One Earth Solar Farm

Statement of Common Ground with Nottinghamshire Fire and Rescue Service [EN010159]

EN010159/APP/8.8.2

July ~~October~~ December 2025

Figure 2.1: Illustrative Layout West BESS Site

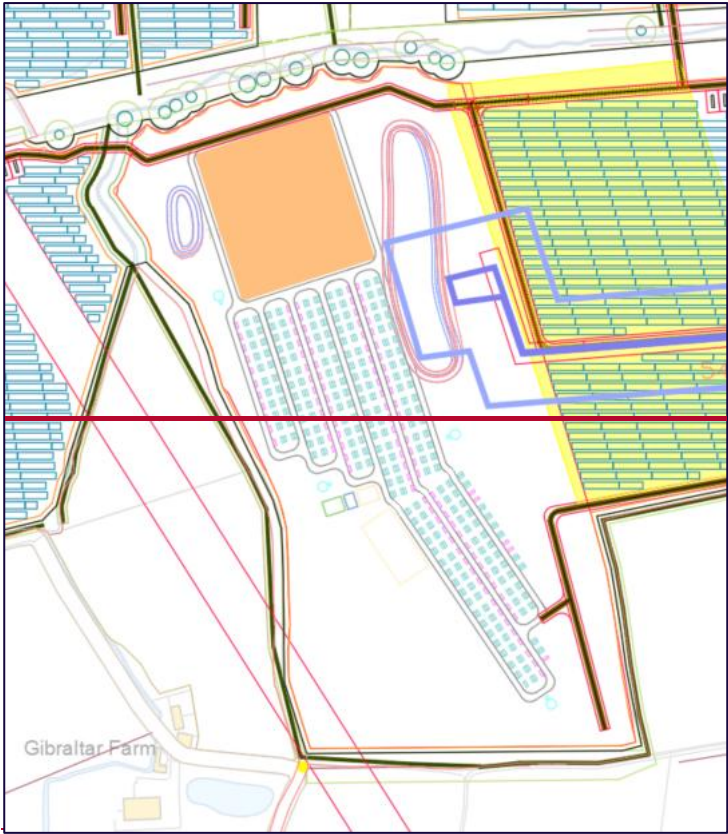
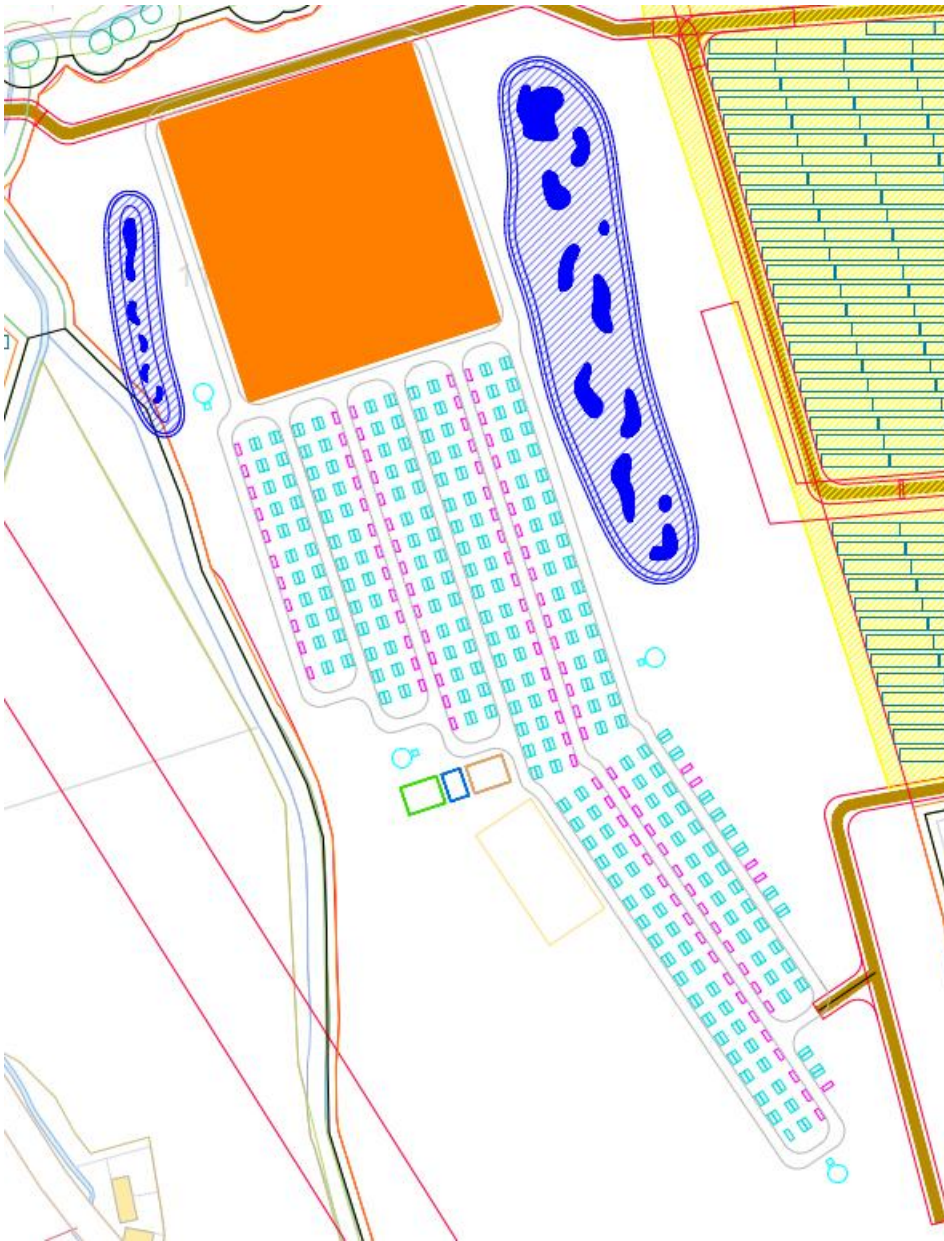
this may influence any subsequent risk management and emergency response plans detailing the requisite safety provisions expected for the site. Whilst The Fire Authority does recognise burn out as a potential means to resolve an emergency of this type on site, it is not the role of the Fire Authority to authorise it.		
	Two access points	The Fire service highlights the importance of the provision of access, that being suitable safe access into and out of the site at all times irrespective of wind direction and incident location Battery energy storage systems safety and fire-fighting response.	Roads accessing the BESS areas will be suitably sized to allow for fire tender access, with routing to be confirmed. This was initially discussed during the meeting with the Nottinghamshire and Lincolnshire FRS on 07 March 2025 and will be further reviewed and confirmed through ongoing engagement with them. Minimum width of roads: 6m	Agreed Under Discussion

For the West BESS Site: An access route from the north of the West BESS Site from the adjacent internal solar access road. A second access route from the internal solar farm access road either at the south or east of the West BESS Site. For the East BESS Site: An access point west or north of the East BESS Site from the A1133, Collingham Road. An access point from the solar access road in the east through the middle of the East BESS Site. At least two access points into the site from a public road.	
--	--	--	--	--
